Frodsham Solar

Environmental Statement: Volume 2

Appendix 9-5: Consultation Responses

May 2025

Drawing file: published-documents / EN010153-000101-6.2_ES Vol 2 Appendix 2-1 Indicative Watercourse Crossing Schedule.pdf

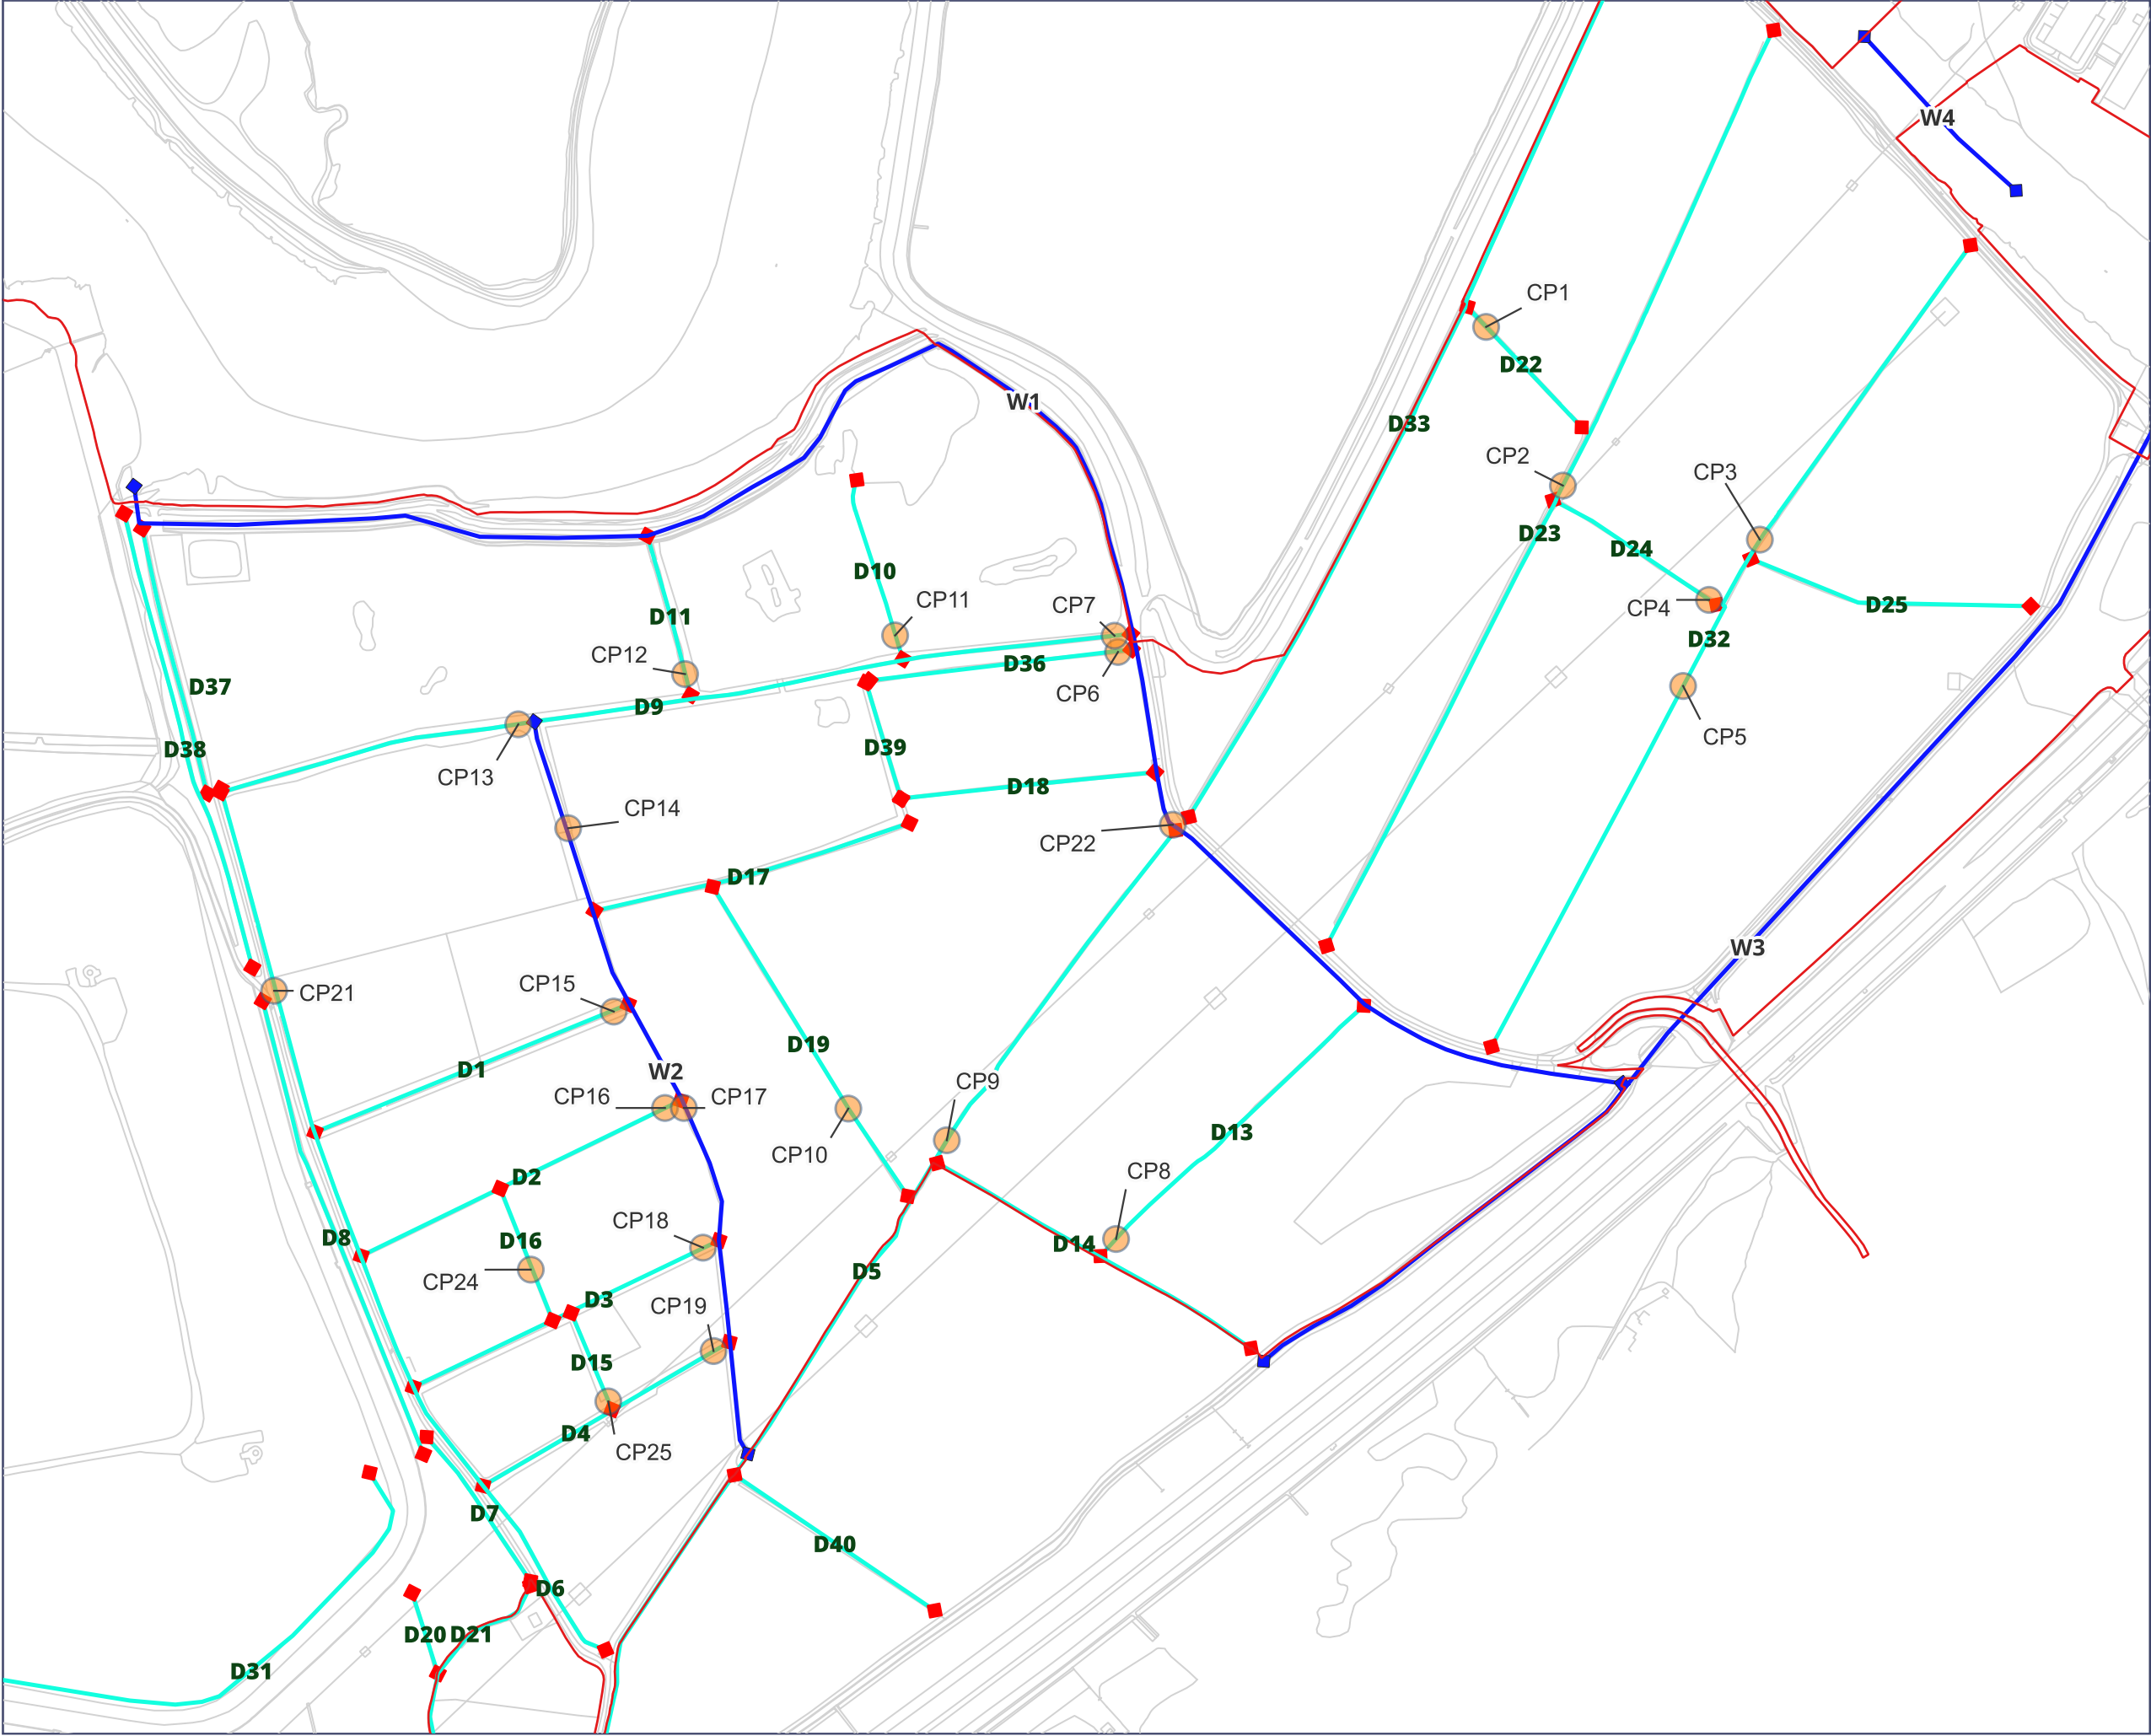
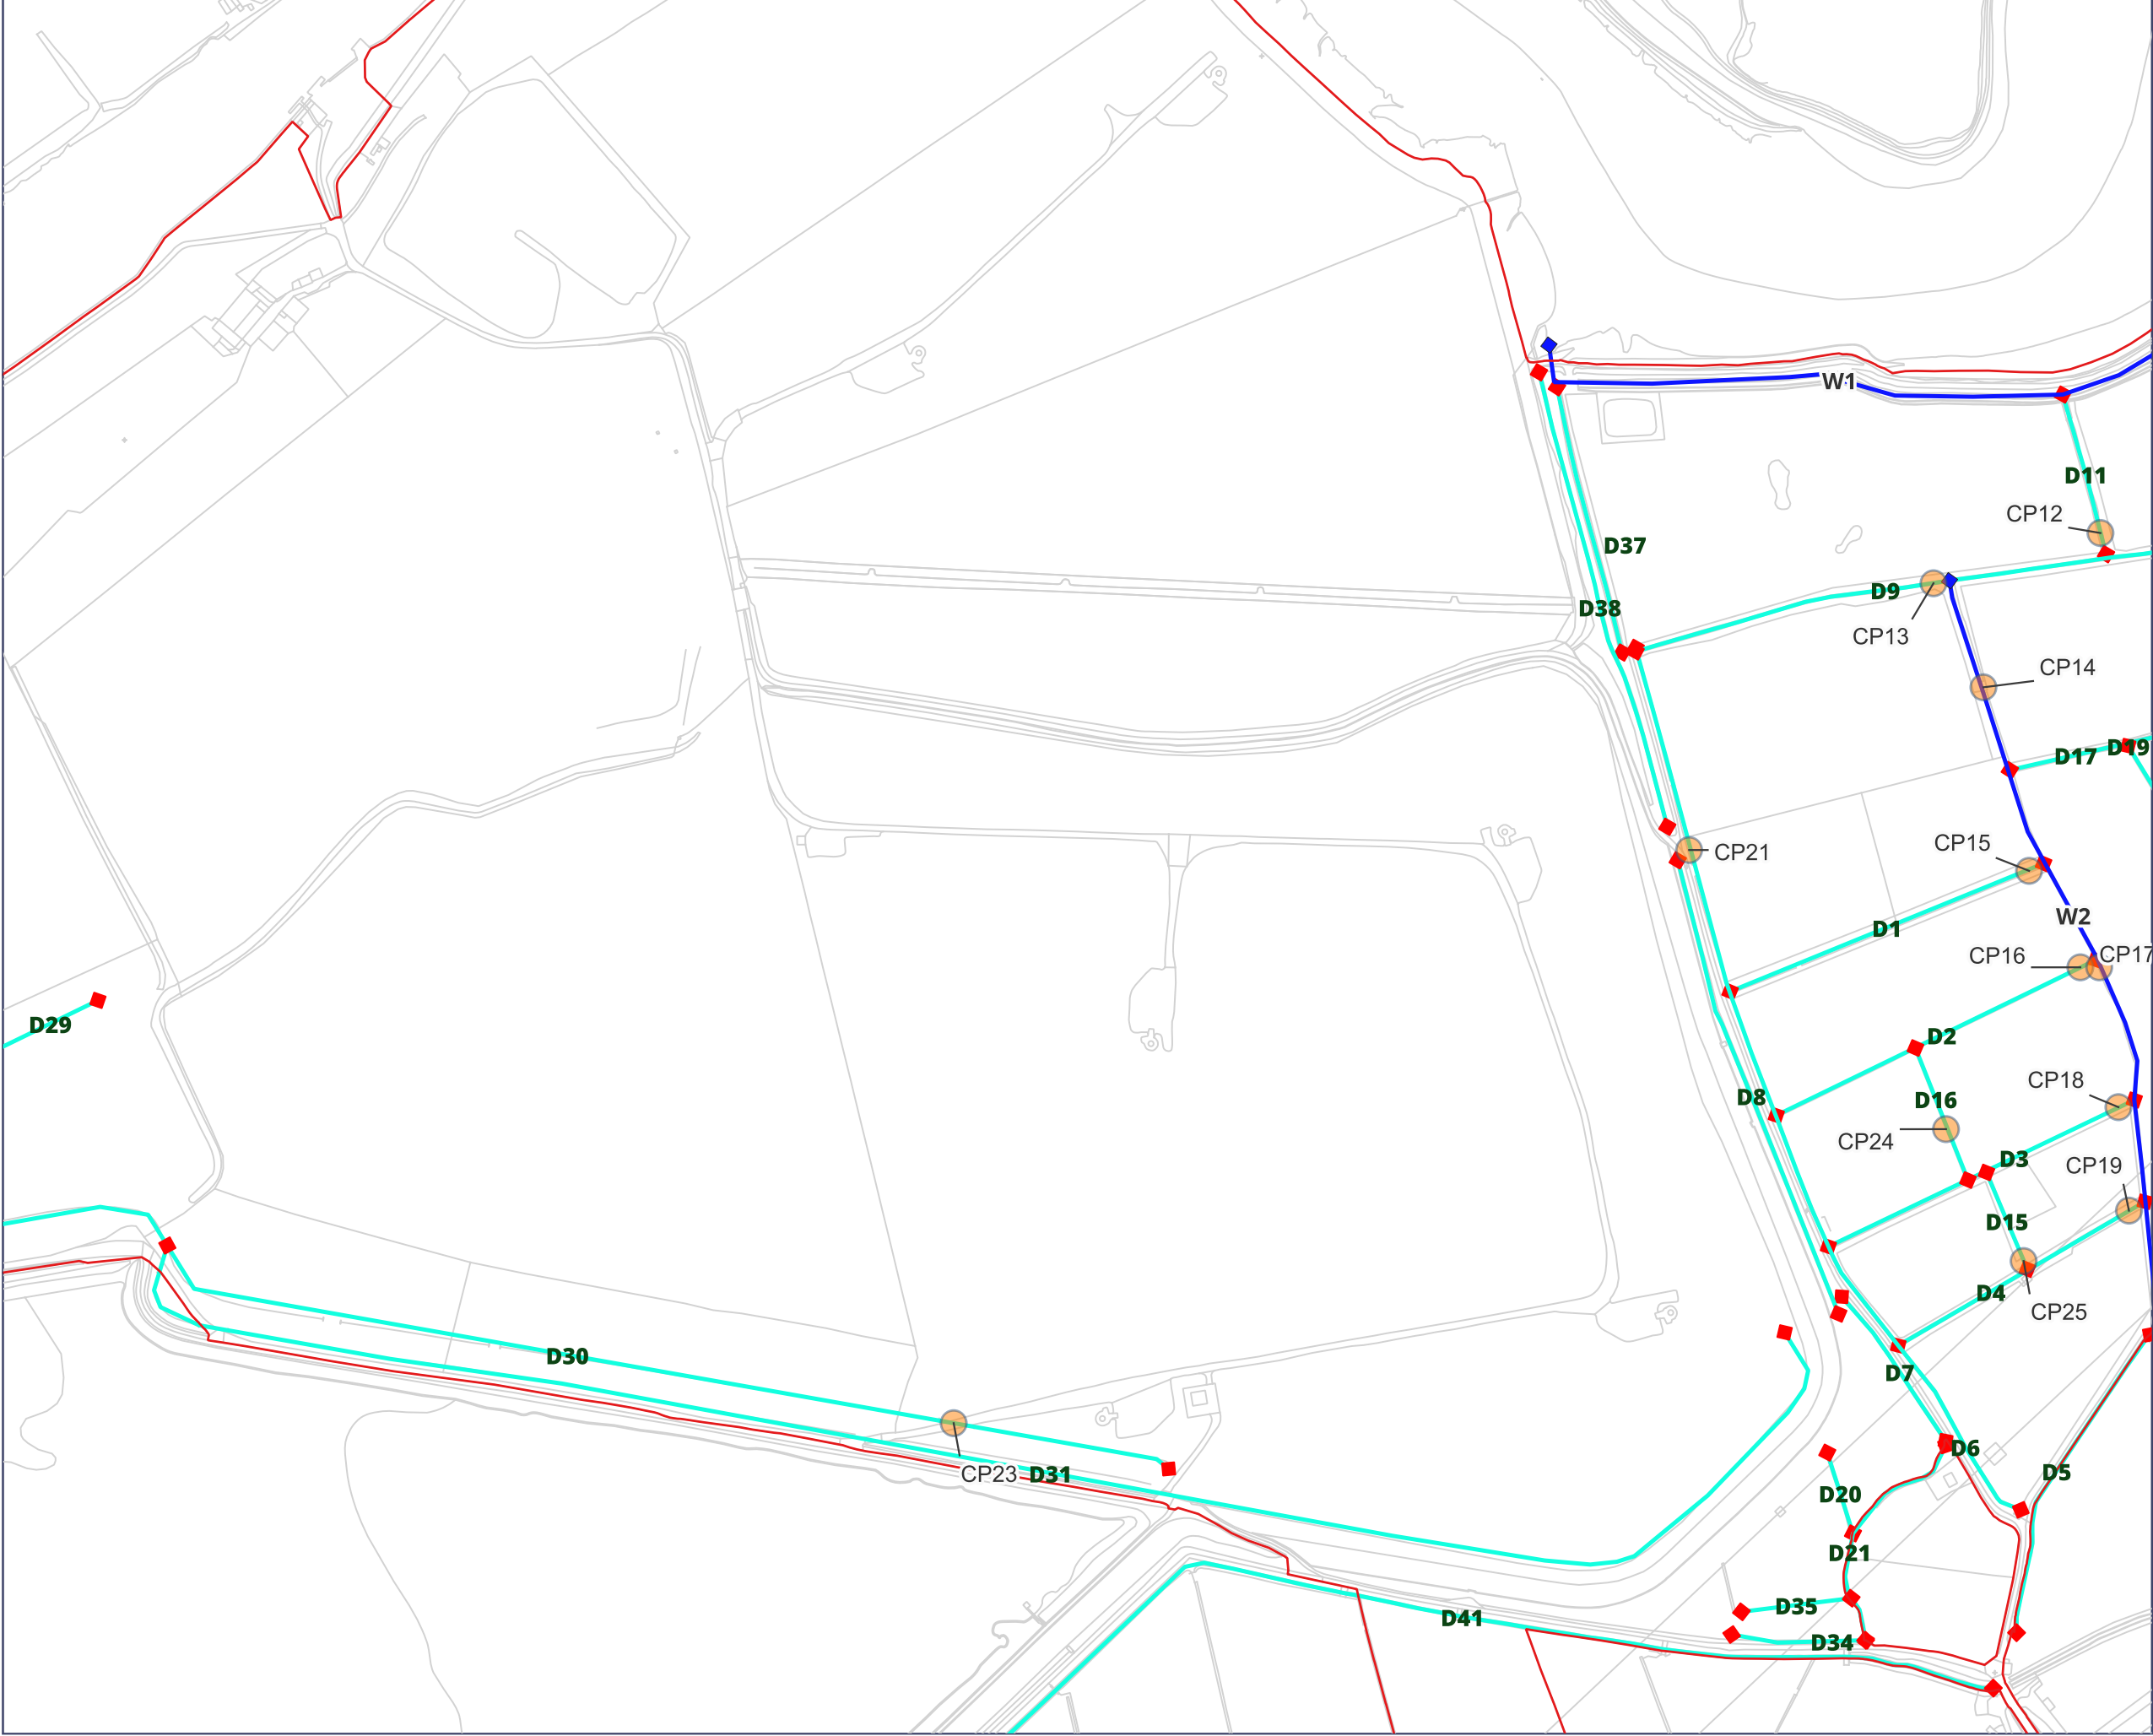
| Respondent | Comment | Has this resulted in a change to the Scheme or the Applicant's evidence? | Applicant response |
|--------------------|--|--|--|
| Environment Agency | Bridge and Cable Crossings of Watercourses (Non-Technical Summary, Paragraphs 2.4.118, 2.5, 3.2.2. Appendix 2-1 Indicative Watercourse Crossing Schedule. Table 2-9: Further associated development within the draft Order Limits in connection with the delivery of Work Nos 1 – 6. Figure 2-5j Indicative Permanent Watercourse Crossing.) Issue We are concerned with details of the proposed crossings, namely the: • the soffit level of the bridges • the potential | Yes | Detailed technical consideration of all crossing points has been made with full details provided in the ES Volume 2 Appendix 9-1: Flood Risk Assessment and Drainage Strategy [EN010153/DR/6.2]. No culverts proposed. All new or replacement access crossings over EA designated Main Rivers will comprise open span bridge structures with a soffit level set 600mm above the |

| Respondent | Comment | Has this resulted in a change to the Scheme or the Applicant's evidence? | Applicant response |
|--------------------|---|--|--|
| | <p>extension of existing culverts Impact The bridges may restrict future maintenance of the watercourse and works to flood assets. Culverts can lead to an increase in flood risk, have a risk of blockage, and pose a maintenance burden.</p> <p>Solution Alternative cable crossing options should be considered. The soffit levels of bridges should be raised 600mm above the design flood level. We recognise this may have knock on effects to the proposed development, and would encourage the developer to liaise with us further on this issue. Instead of installing / extending (existing) culverts, the applicant should consider installing a clear-span bridge crossing. Given that there are circa 25 crossings as part of this proposal, the applicant will need to model changes in flood risk from the proposed crossings.</p> <p>Our position on this is supported by paragraphs 2.10.87 and 2.10.88 of National Policy Statement EN-3, which state that: • culverting existing watercourses should be avoided • where culverting for access is unavoidable, applicants should demonstrate that no reasonable alternatives exist, and where necessary it will only be in place temporarily for the construction period.</p> | | <p>1% annual probability plus 67% climate change in-channel water level of the relevant watercourse.</p> <p>All new or replacement access crossings over designated 'Ordinary Watercourses' will comprise open span bridge structures with a soffit level set above the top bank level of the watercourse.</p> <p>The watercourse crossings will not reduce the channel capacity and as such will not impact on flood risk on site or elsewhere.</p> <p>Please see the Bridge Design Technical Note appended to the ES Volume 2 Appendix 9-1: Flood Risk Assessment and Drainage Strategy [EN010153/DR/6.2].</p> |
